**Town & Country Planning Act 1990 (as amended)
Town and Country Planning (Development Management Procedure) (England) Order 2015
Application for Planning Permission**

Development Change of use from Horticultural to storage of containers, caravans & garden equipment, erection of green palisade fencing to front of site behind the existing hedgerow, increase planting buffer to front & side & 4 No. CCTV cameras.

Location Fresh Acres Nursery Yapton Lane Walberton

drawing
Location Plan
As Existing

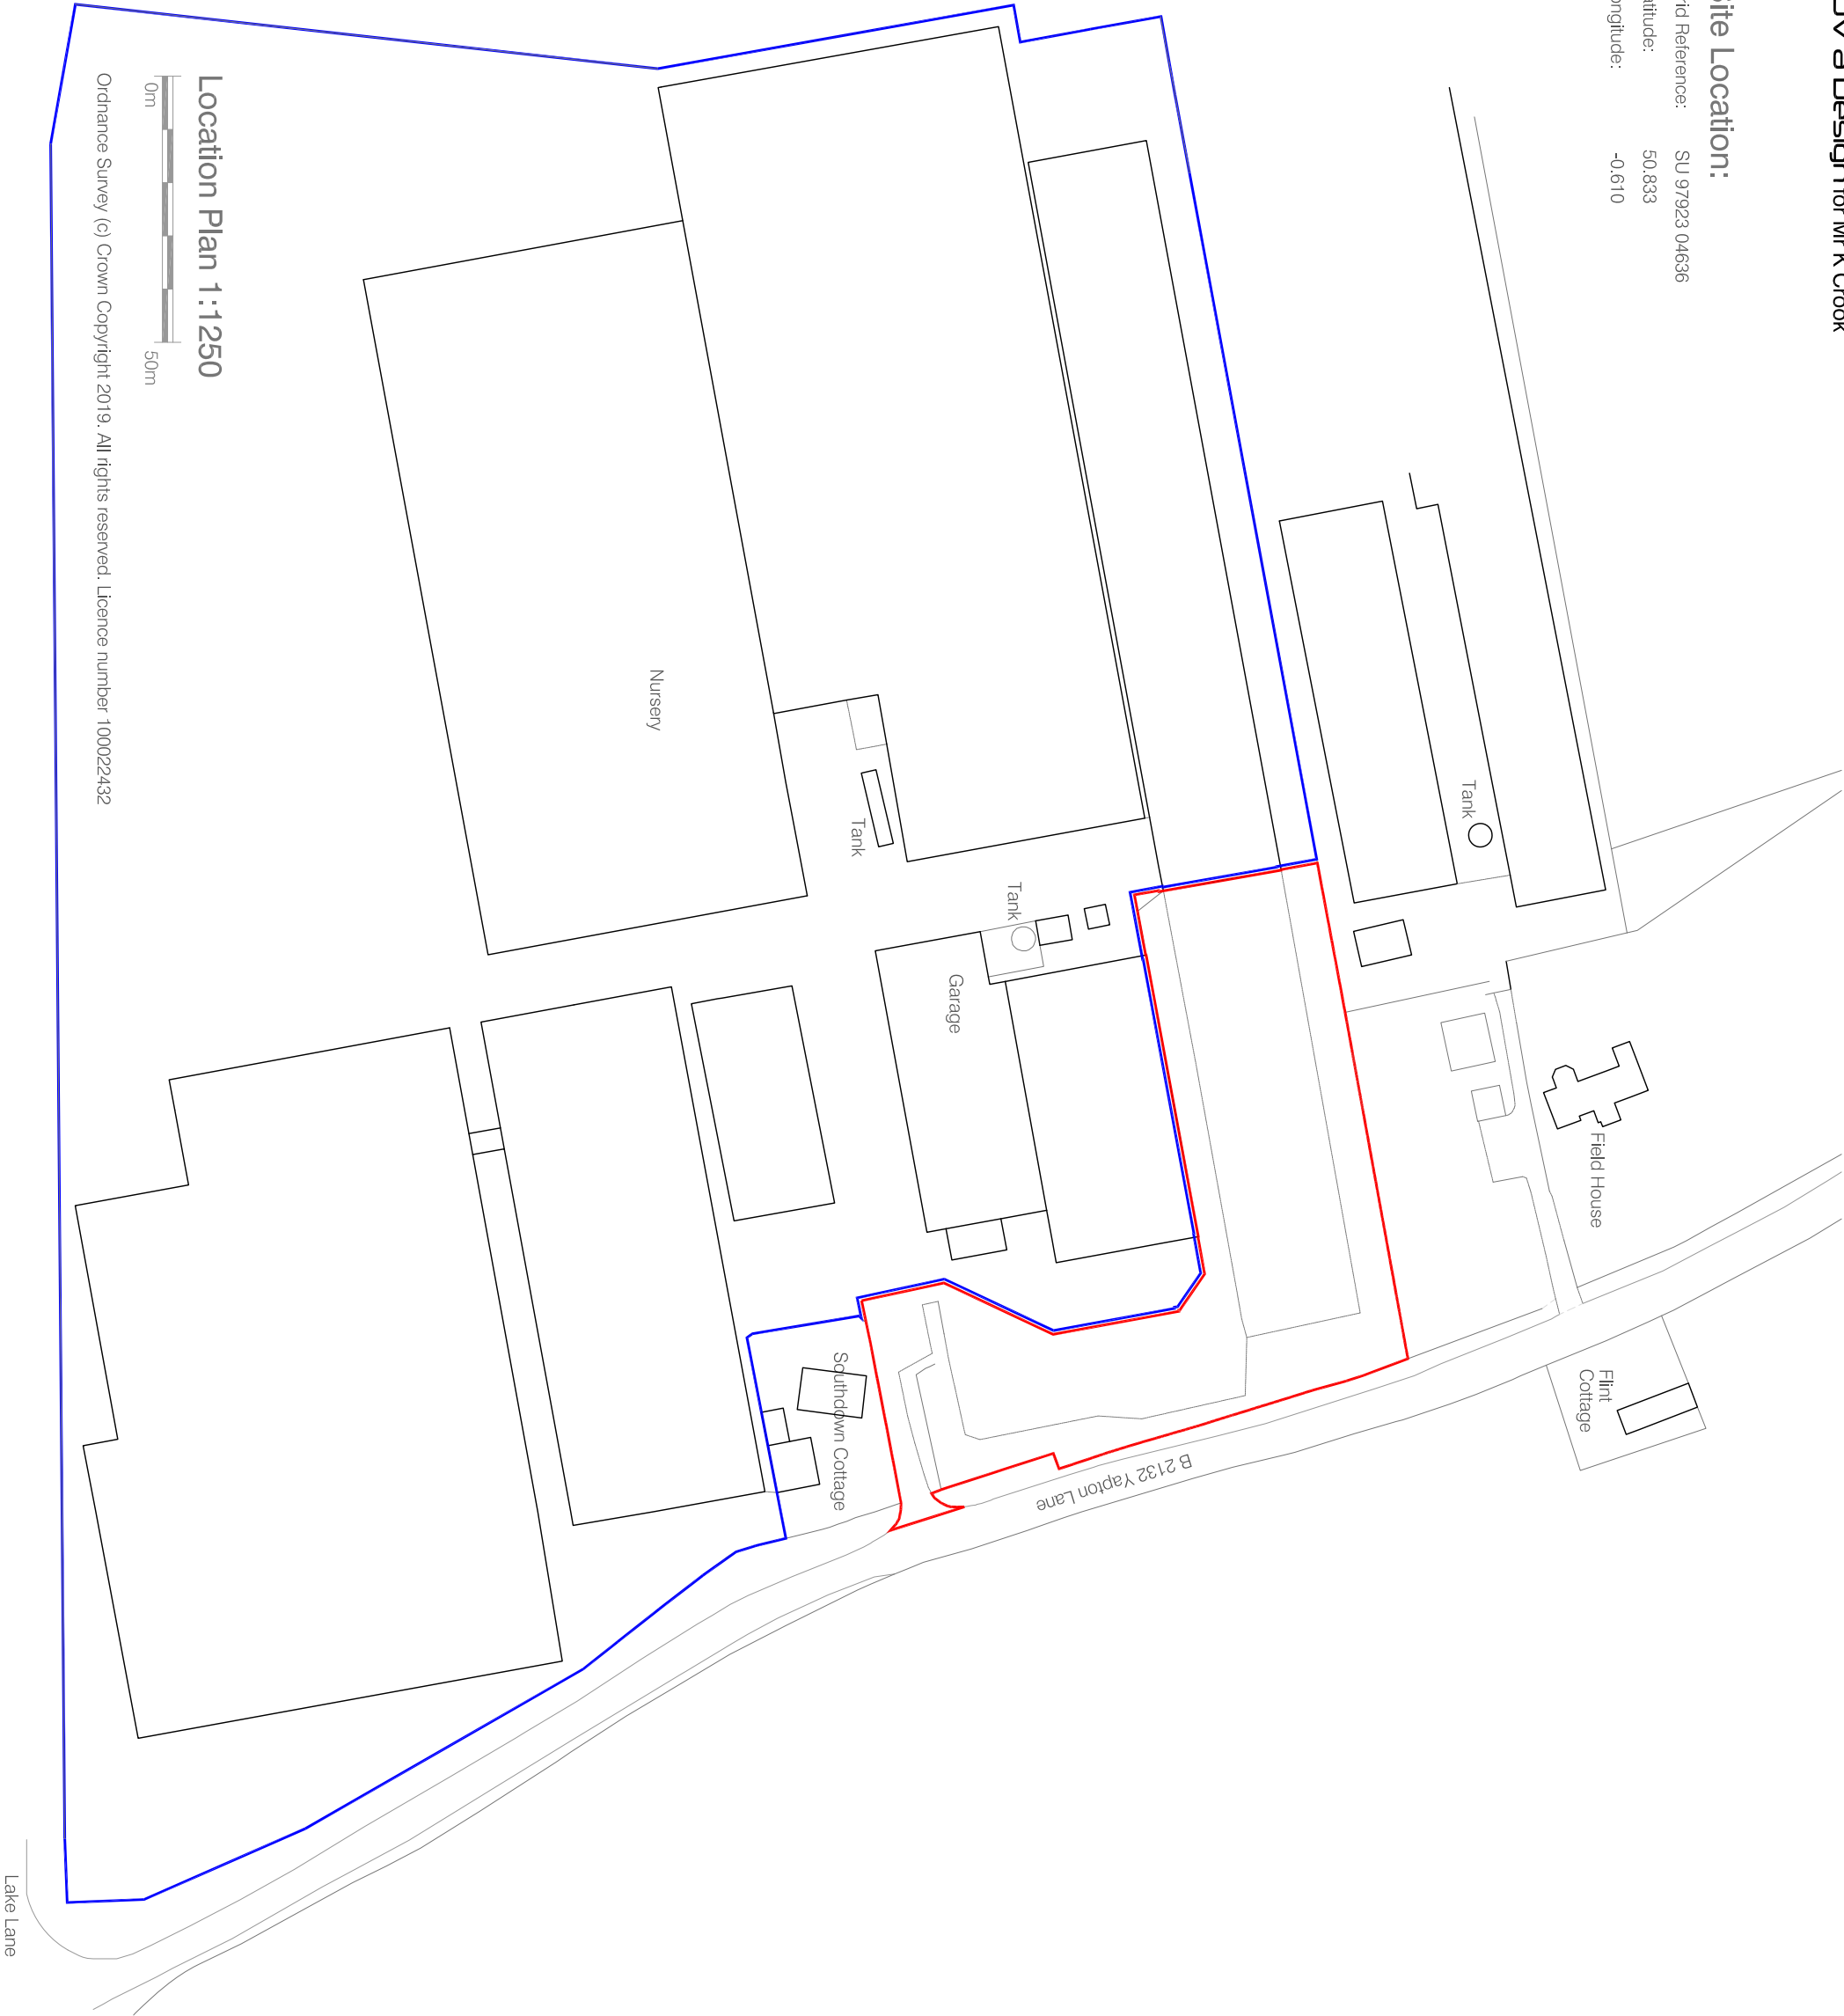
Location Plan Amend

Please provide a full blue edge.
